Thank you for your email received 23 September 2019 seeking WaterNSW's comments on Goulburn Poultry Processing Mixed Use development (SSD 9143). WaterNSW appreciates the opportunity to provide detailed comments on this proposal.

WaterNSW has reviewed the Environmental Impact Statement prepared by KDC (dated 1 August 2019) and undertaken a site visit. WaterNSW has the following concerns regarding the water quality impacts from this application:

**PROPOSED PROCESSING FACILITY
 OVERALL SITE PLAN - FINAL STAGE - NO CONTOURS**

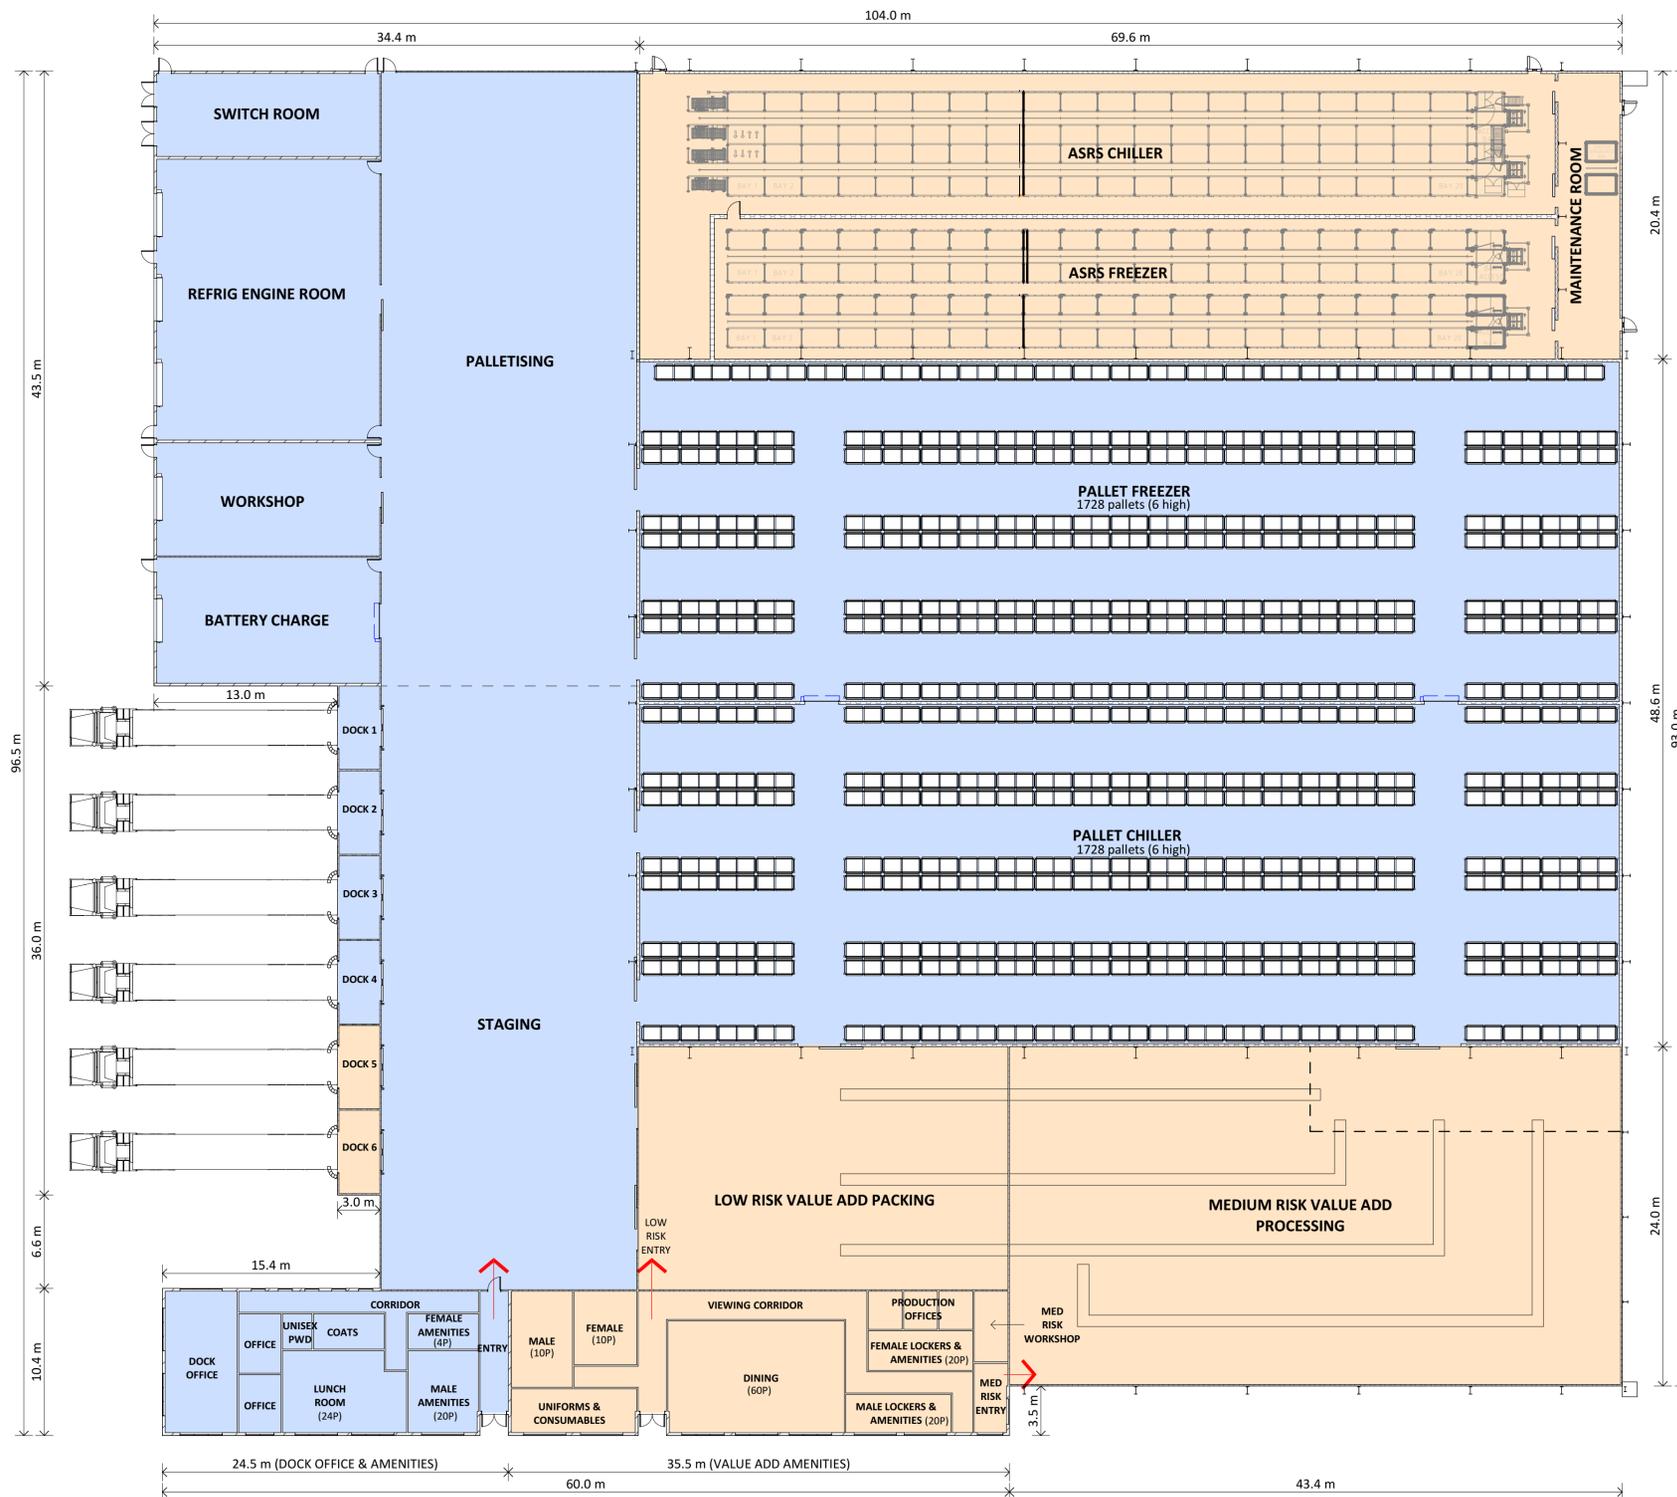
- the quantity of wastewater that would be produced in Stage 1
- the management of washdown water from the proposed truck maintenance facility
- whether there is enough space on-site for both the proposed Moving Bed Biological Reactor (MRRB) tank and stormwater detention basin
- MUSIC stormwater quality model that meet the requirements of the relevant CRP, and
- a soil and water management plan showing how the proposed bioretention system will be protected during the construction of Stage 2 of the proposal.

- the Water Management Plan
- the Civil Works Plans, and
- the Overall Site Plan.

STORMWATER MANAGEMENT PLAN  
PROPOSED PROCESSING FACILITY  
52 SINCLAIR STREET,  
GOULBURN  
WOODLAND RIDGE POULTRY PTY LTD

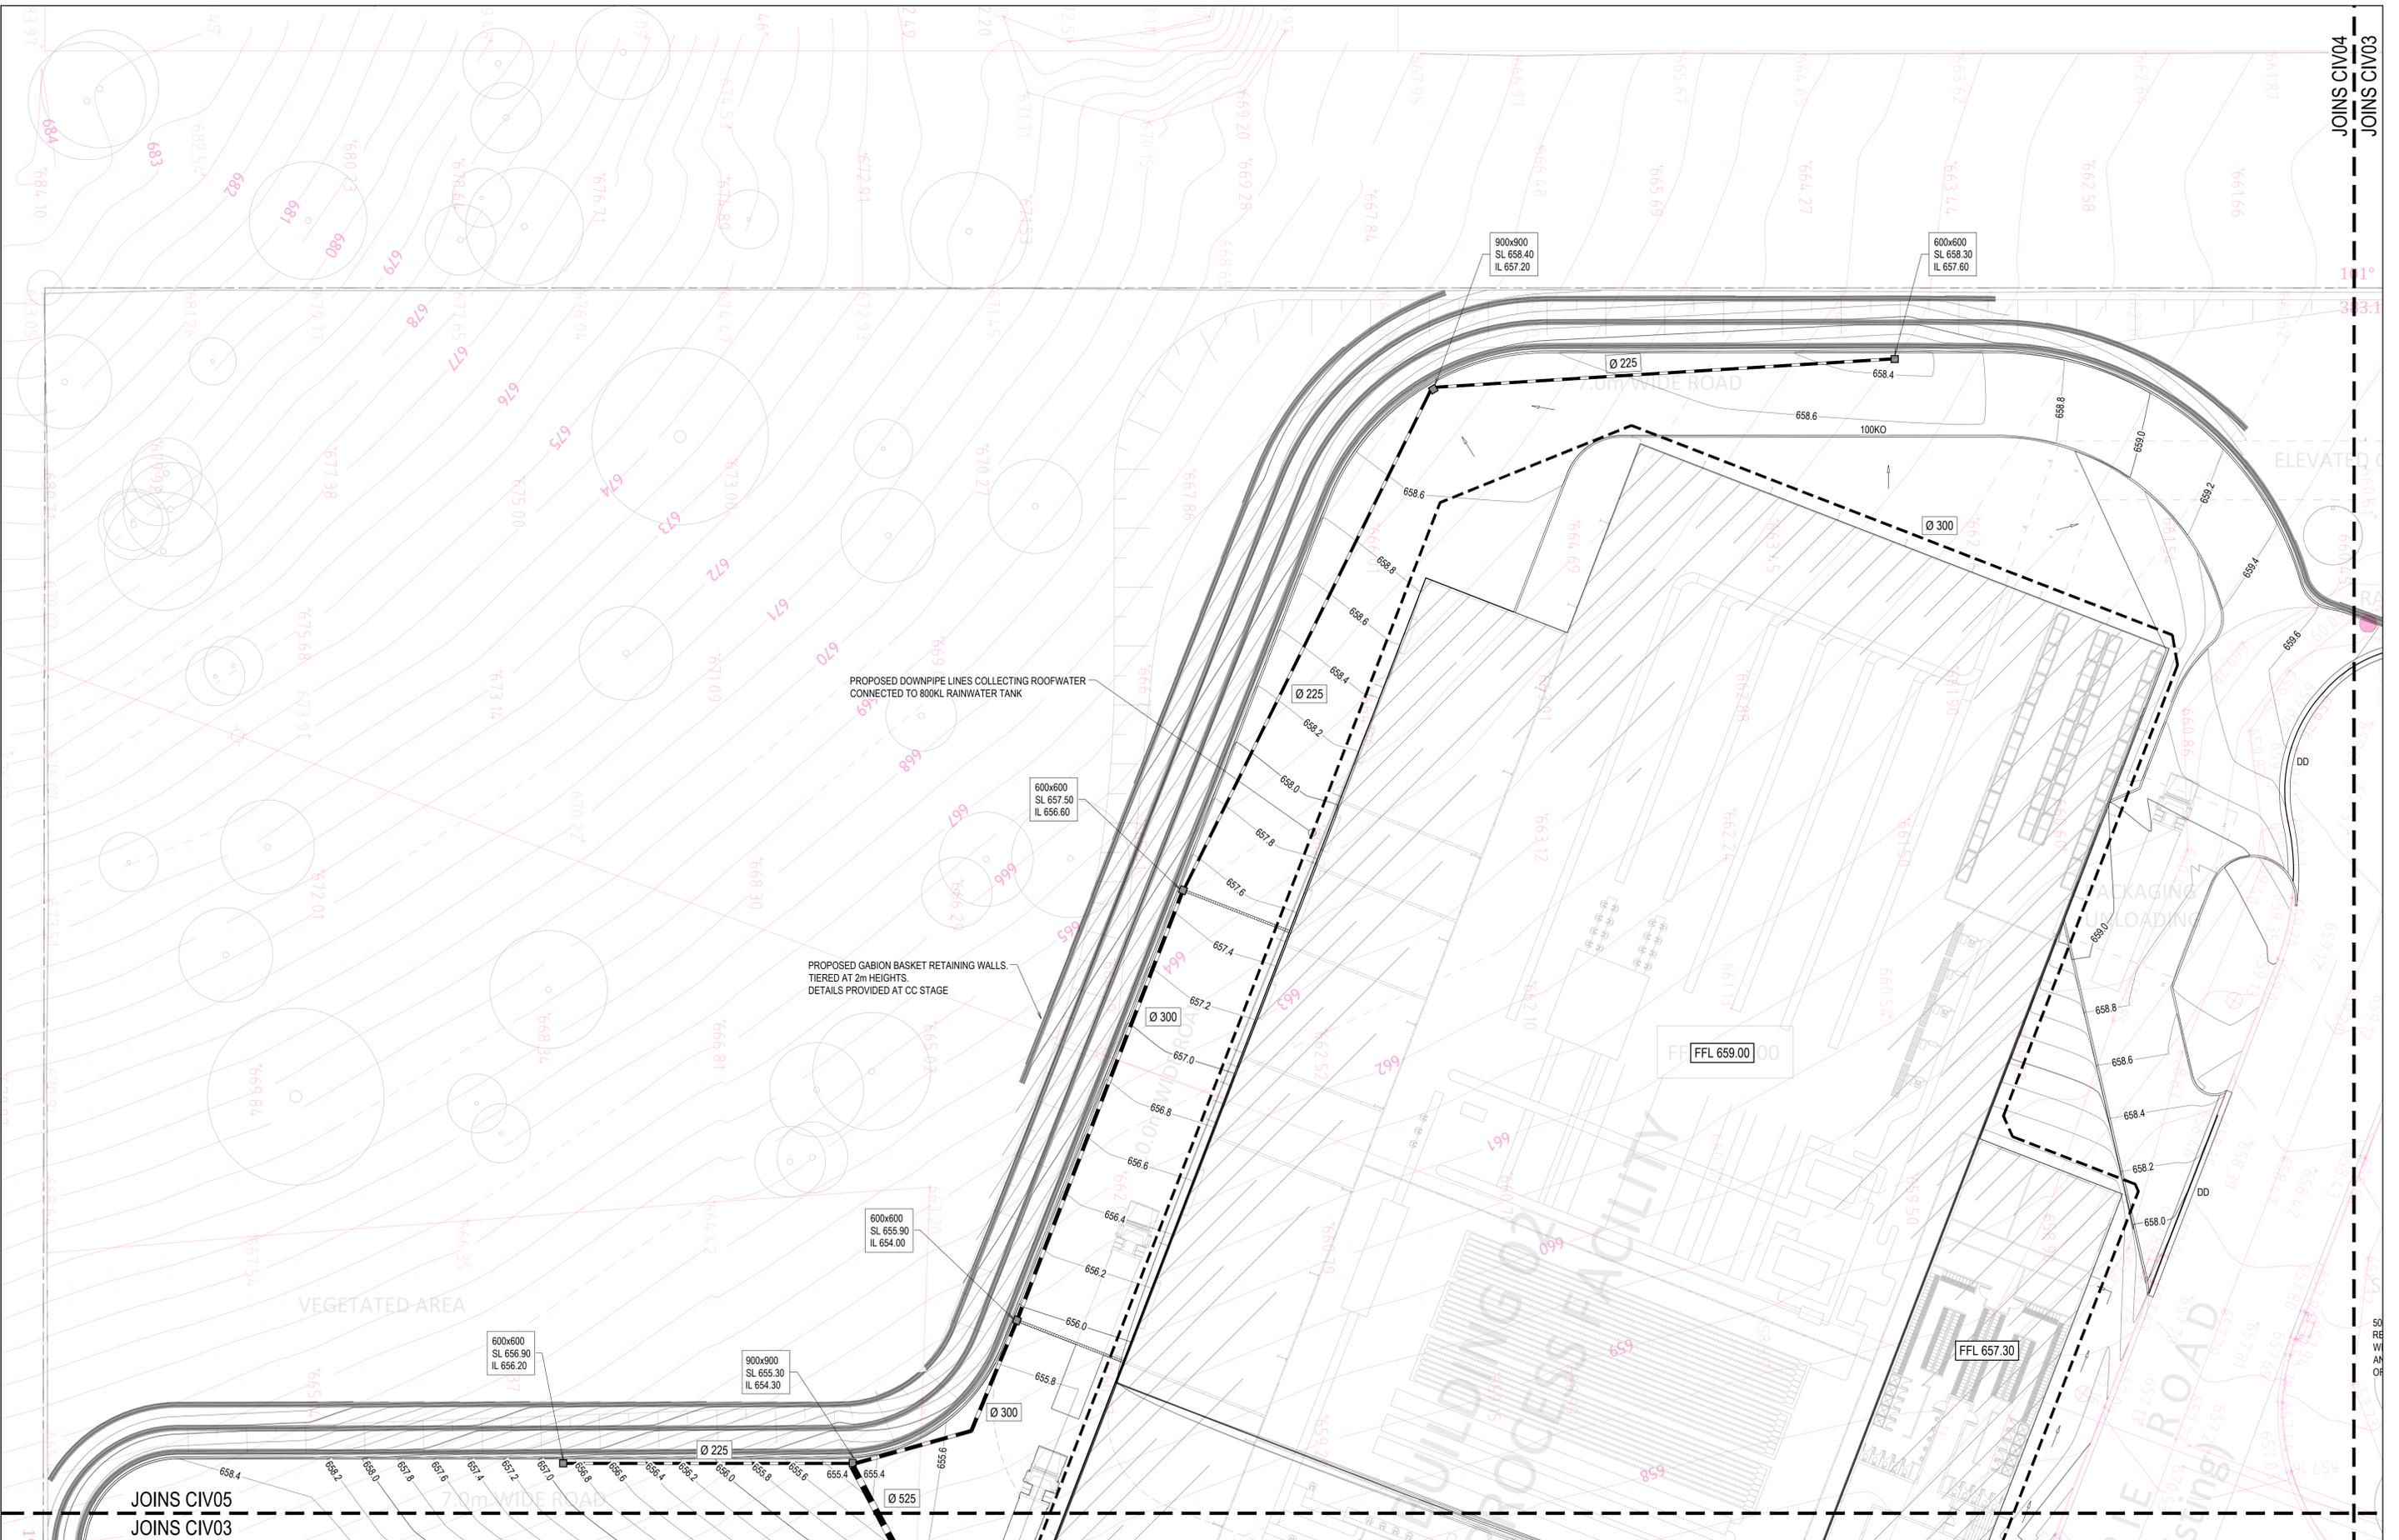
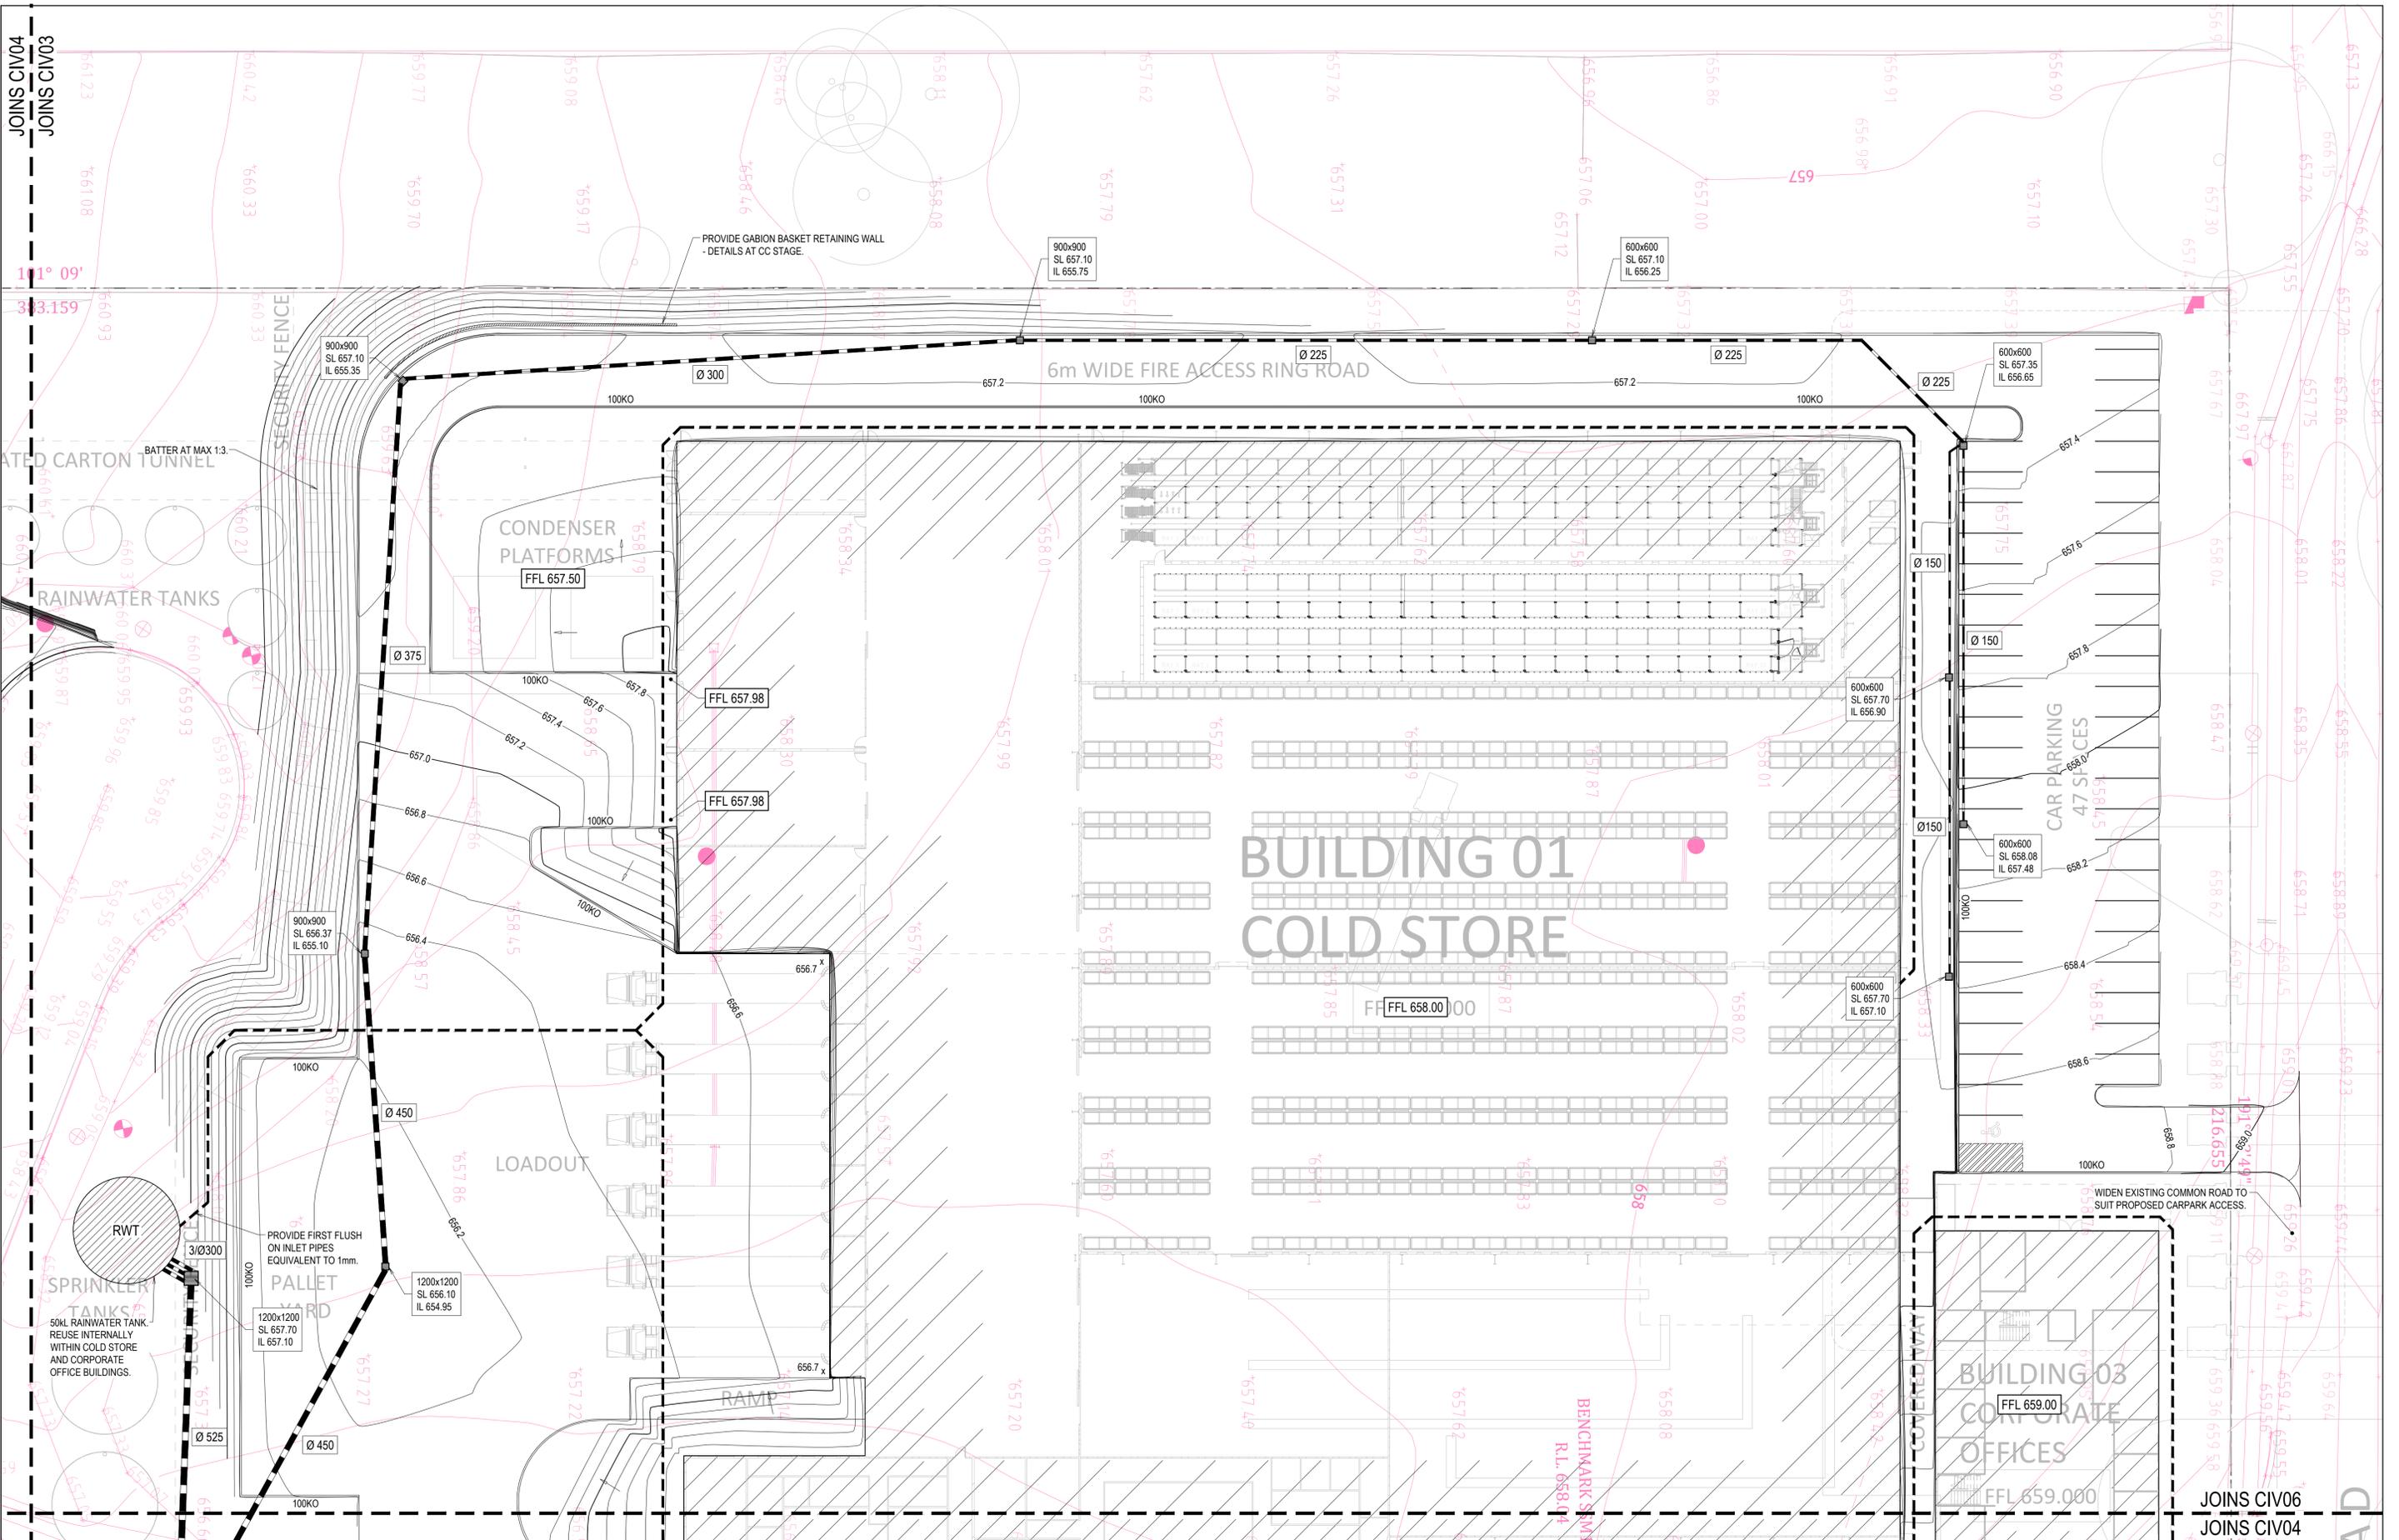
- The proposal does not incorporate all WaterNSW's Current Recommended Practices (CRPs), or demonstrate how the outcomes of those CRPs will be met, as required by Clause 9 of the SEPP (Sydney Drinking Water Catchment) 2011. In particular, Water NSW notes that:
 - Staging has not been considered in the MUSIC stormwater quality modelling or the erosion and sediment control documentation, and
 - the MUSIC stormwater quality model has not been prepared in accordance with the CRP *Using MUSIC in Sydney Drinking Water Catchment* (WaterNSW 2019).
- Consequently, it cannot be determined whether Stage 1 has a neutral or beneficial effect (NorBE) on water quality.
- Further, when WaterNSW amended the MUSIC stormwater quality model to meet the CRP requirements, the final proposal would not comply with the NorBE test on water quality.
